Our Ref: PAA/66/21/

Pre-Application Advice

New detached dwelling on land within/adjacent boundary of site ownership
Oak Bank Wandleys Lane Walberton West Sussex BN18 0QR

Site Block Plan 1:200

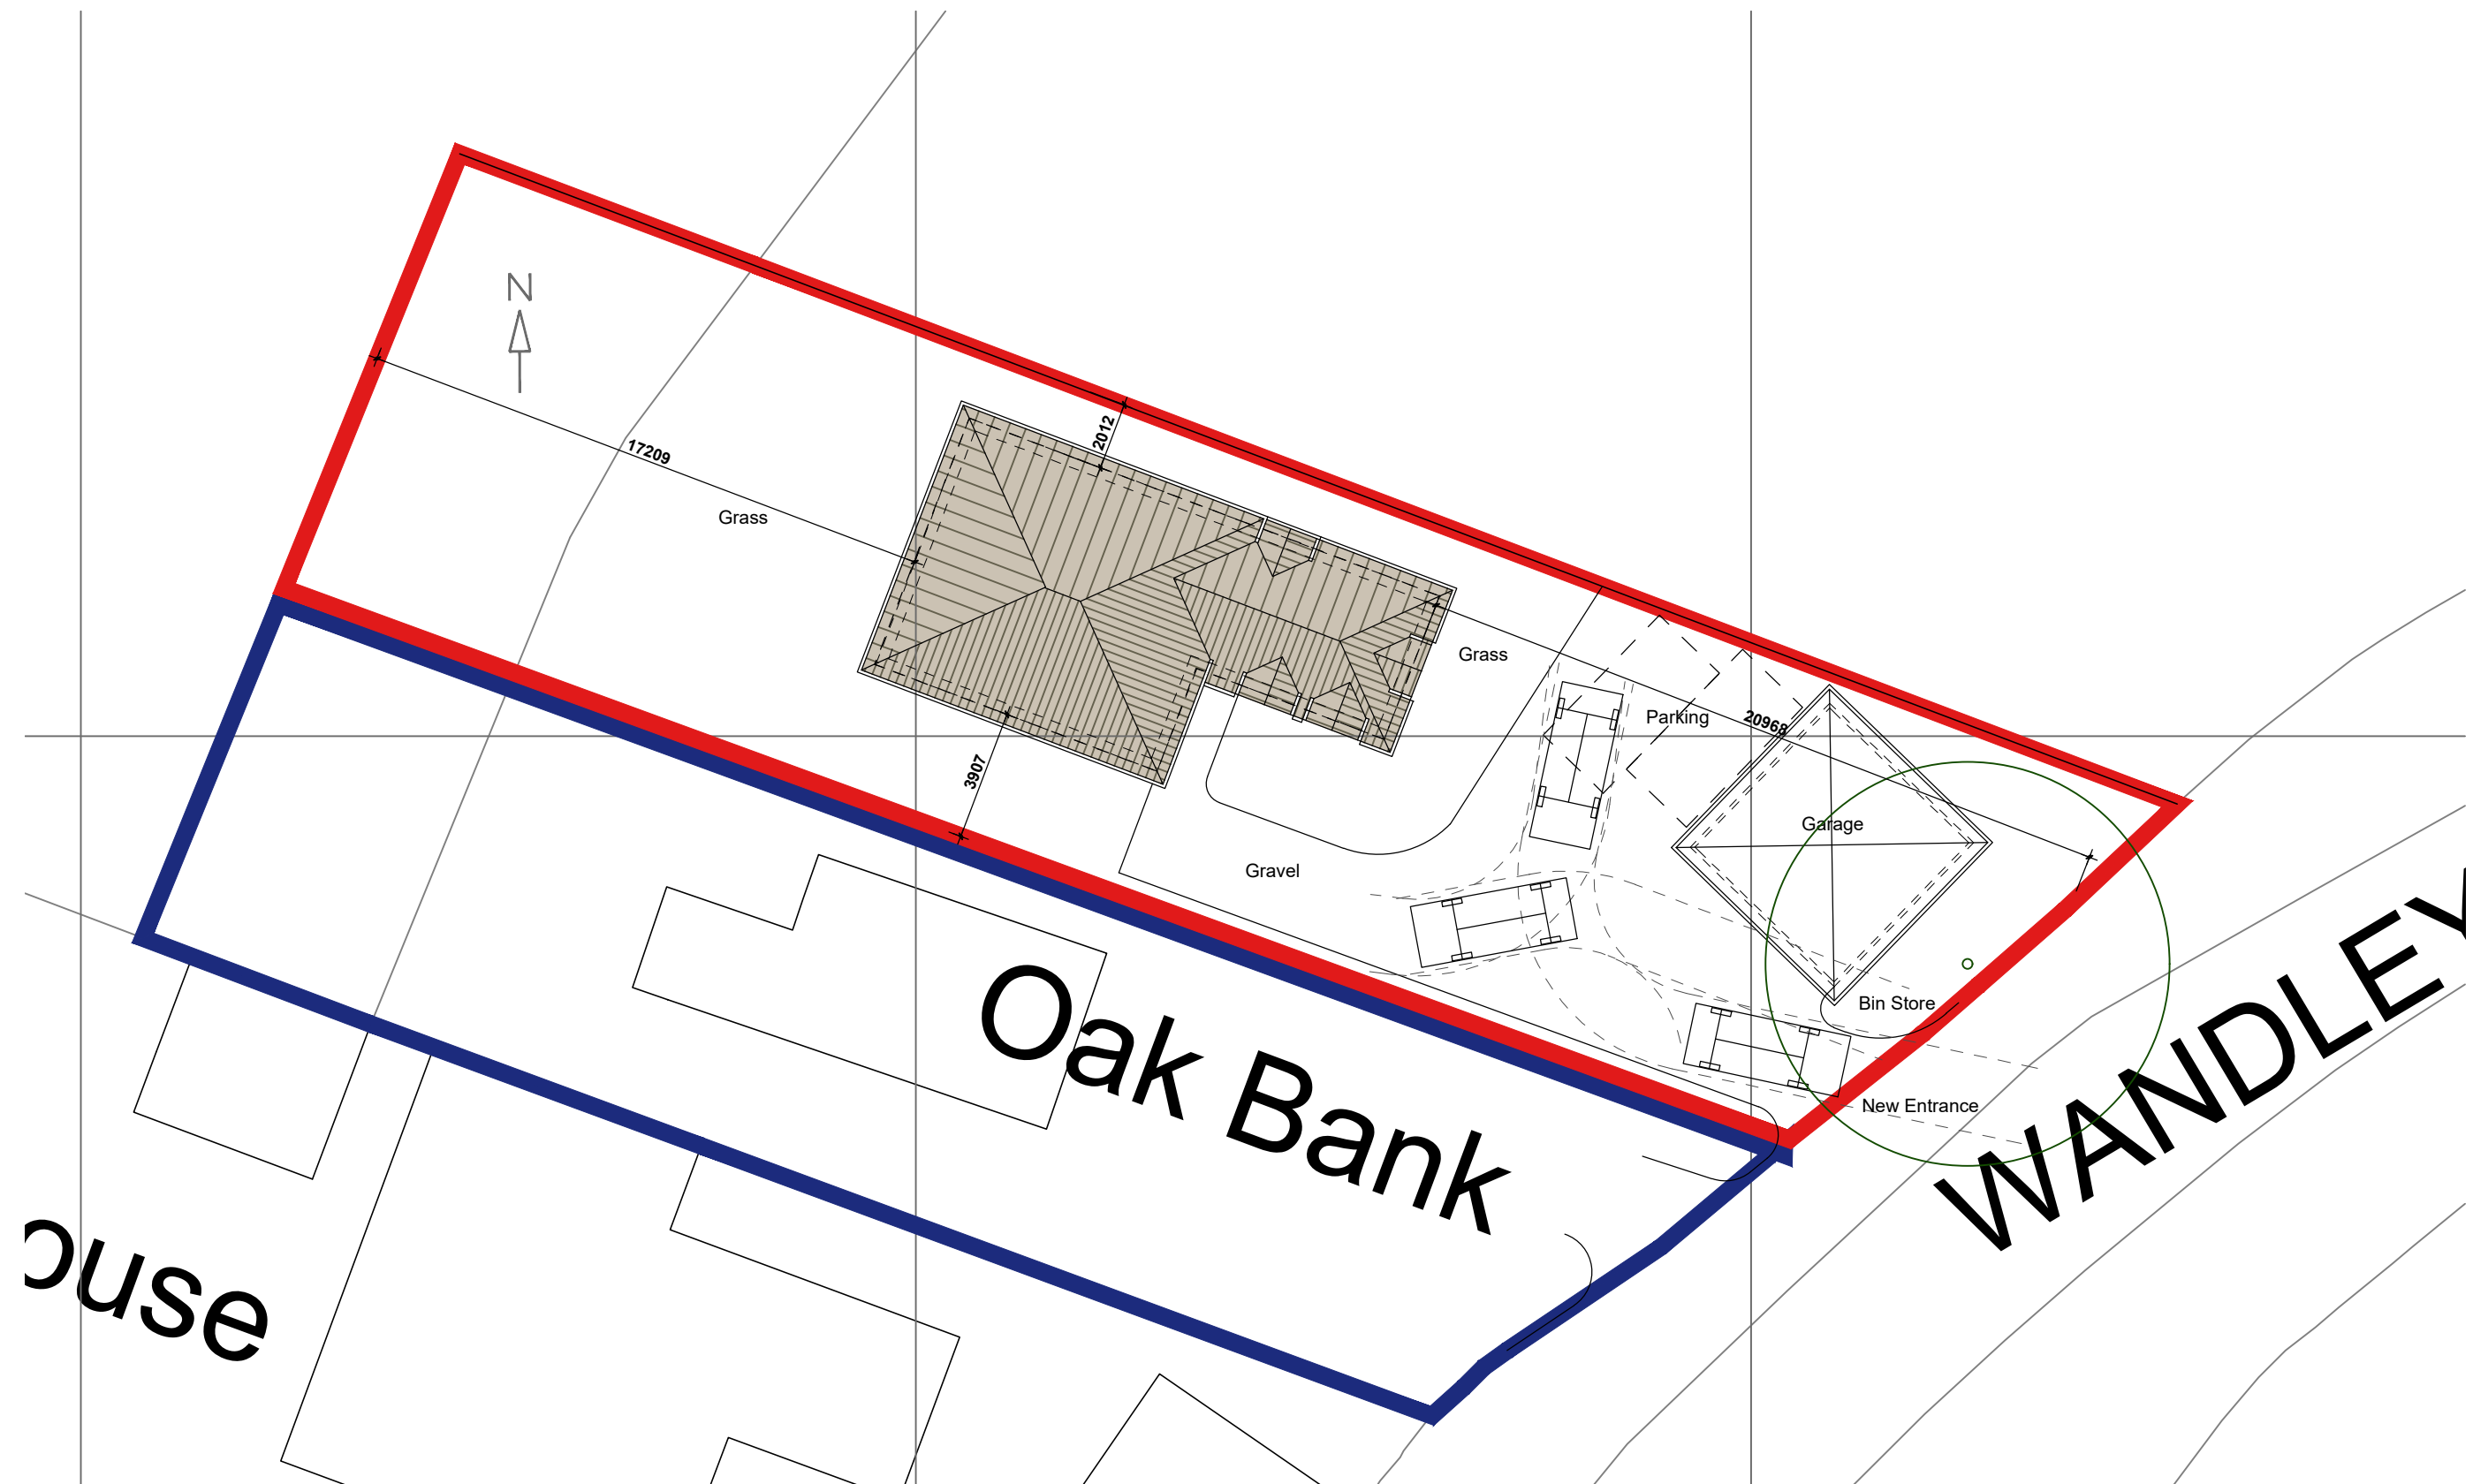
The Site Plan has not demonstrated any parking spaces, but an integral garage is provided. For a garage to be included within parking provision it must have an internal area of 6m by 3m. It is likely there is adequate space available for parking to comply with requirements.

West Elevation

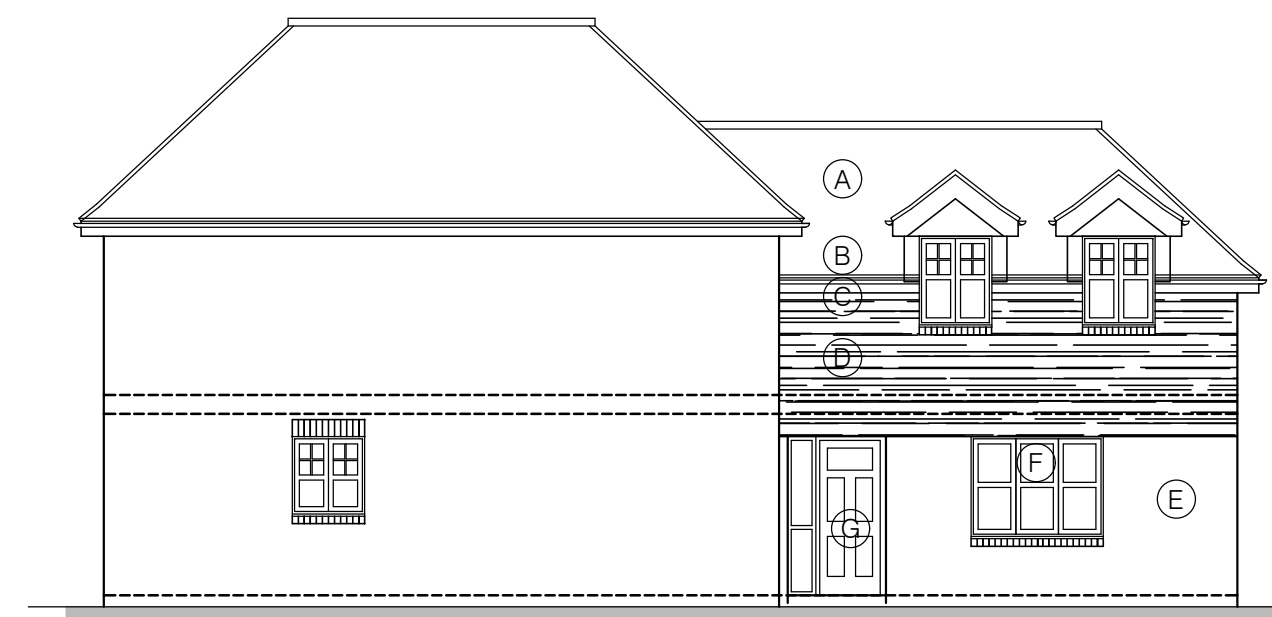
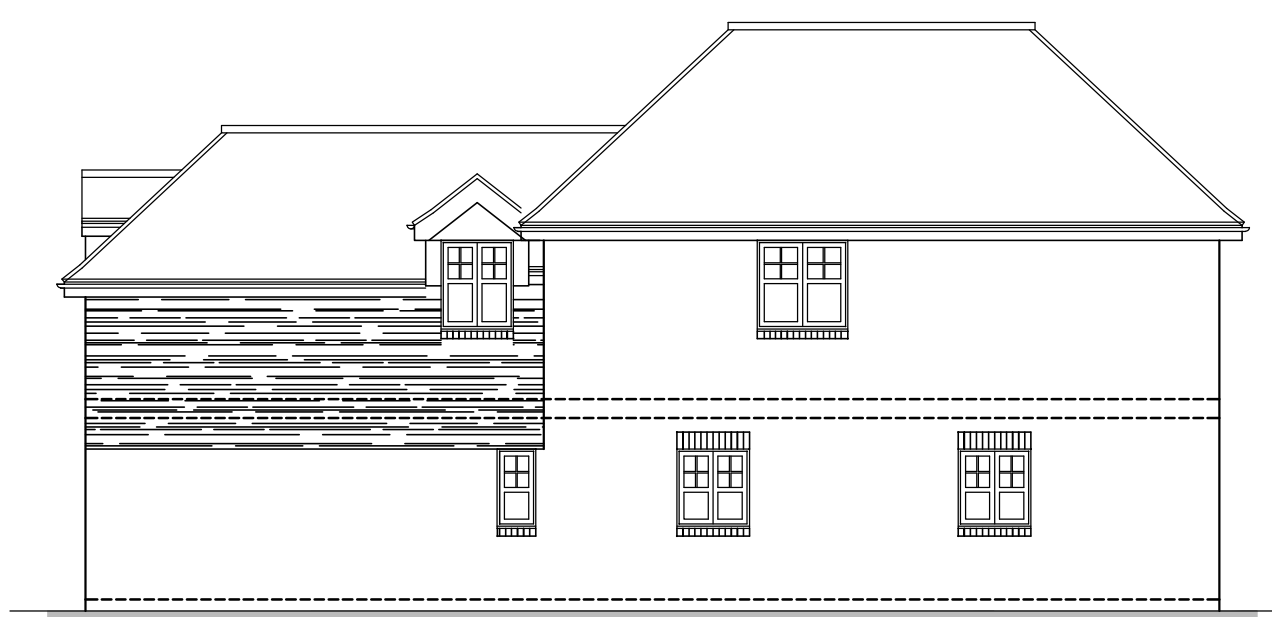
The proposed development is a new residential dwelling sited in a countryside location, although it is acknowledged that the site to the north and east has approval for residential development, it is considered that the height and first floor width of the dwelling would have a

harmful impact on the rural, arboreal character of the area. The proposal introduces a large, prominent new dwelling that appears as an alien feature within the locality and street scene and would be overly dominant in relation to the more modest footprint of the host dwelling Oak Bank.

In design terms the proposal would therefore be overly dominant and damaging to the visual amenities of the locality contrary to policies D DM1 and D SP1 of Arun Local Plan.

The pre-application information that you have submitted does not set out how the proposed residential development accords with the provisions of the National Design Guide or the Arun Design Guide. In the forthcoming detailed planning application you will need to provide a statement supporting your design principles referencing compliance with the Arun Design Guide, even if only provided as supporting information. The site has a rural location and it should be demonstrated that the rural setting and character would be reflected in any development of the site. The space indicated between the dwelling and site boundaries when combined with the 2 storey height of the dwelling which spans the site is considered to be overly dominant in the street scene. It is suggested that one section of the dwelling should be single storey adjacent to the side boundary.
